Subject: RE: 18-070 [External]RE: M/109/21/PL 188 Elmer Road

Simon J Davis MRTPI
Principal Planning Officer
Directorate of Place

Side Elevations

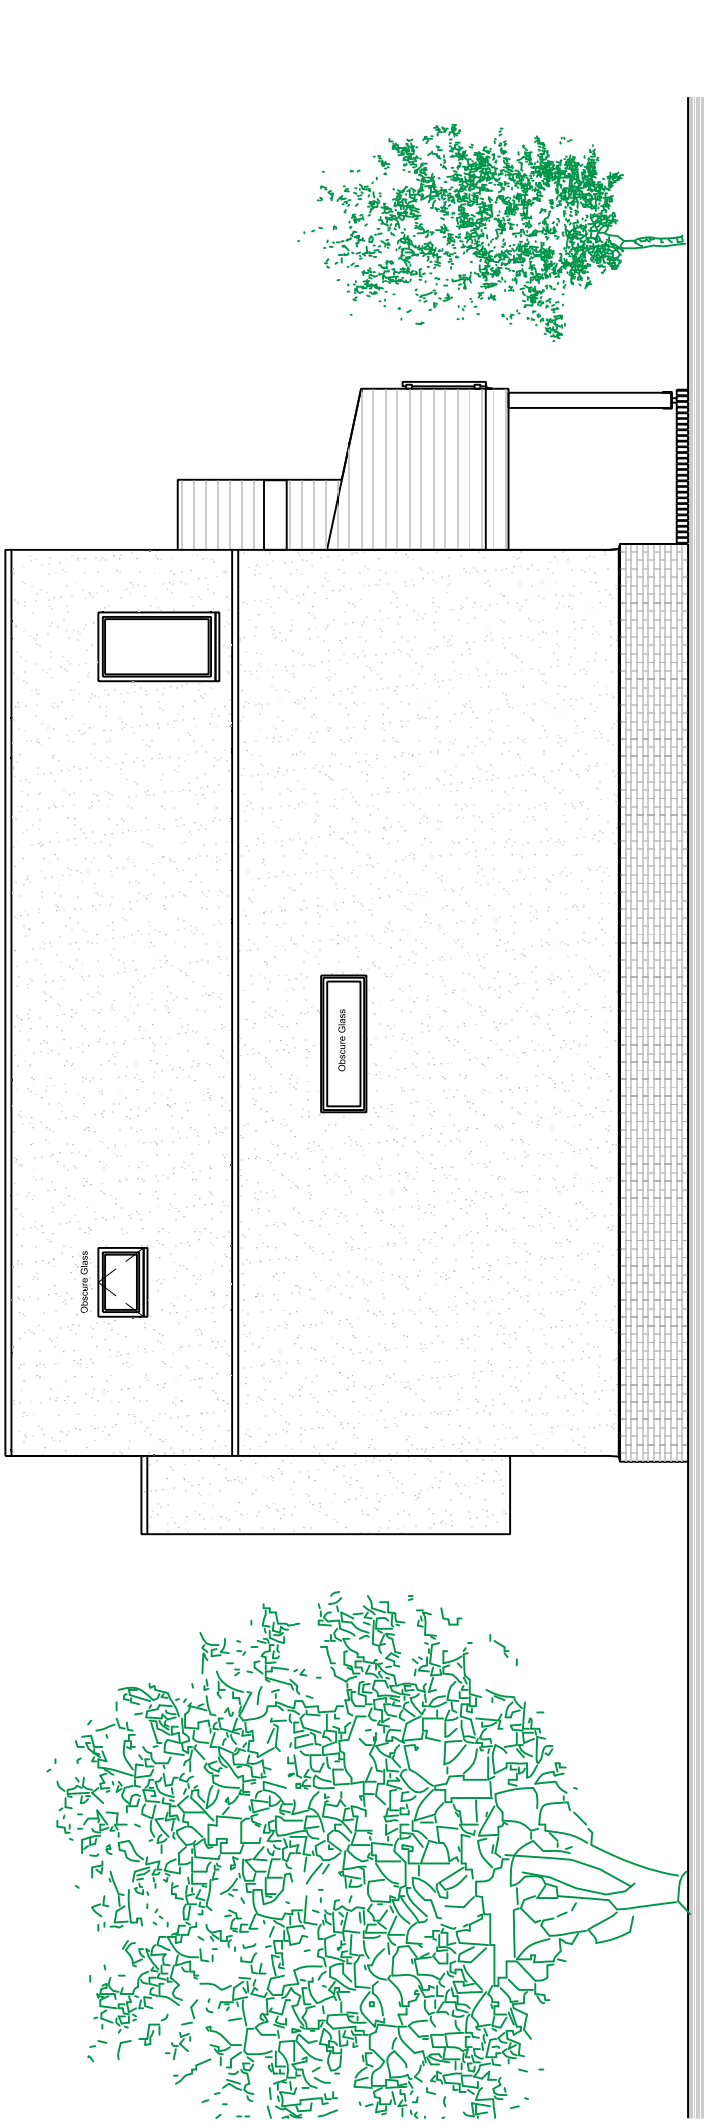
Looking back I see that Ms Cheng agreed on 13/09/21 to provide amended plans reflecting what I had requested. You then asked about the side window and I replied 14/09 to say *"Thanks for your email and photos. I understand what you are saying however, the proposed window is at a greater height than the existing one in the photo and so represents a brand new impact."* To clarify, in that response, I was maintaining my position that I had a concern with the side window and wanted it amended.

We were just wondering if you have had the opportunity to consider the extra photographs we forwarded to you in relation to the 'second floor secondary window on the west flank' As we would like to instruct the designers to make all the required changes you previously suggested and get these to you ASAP.
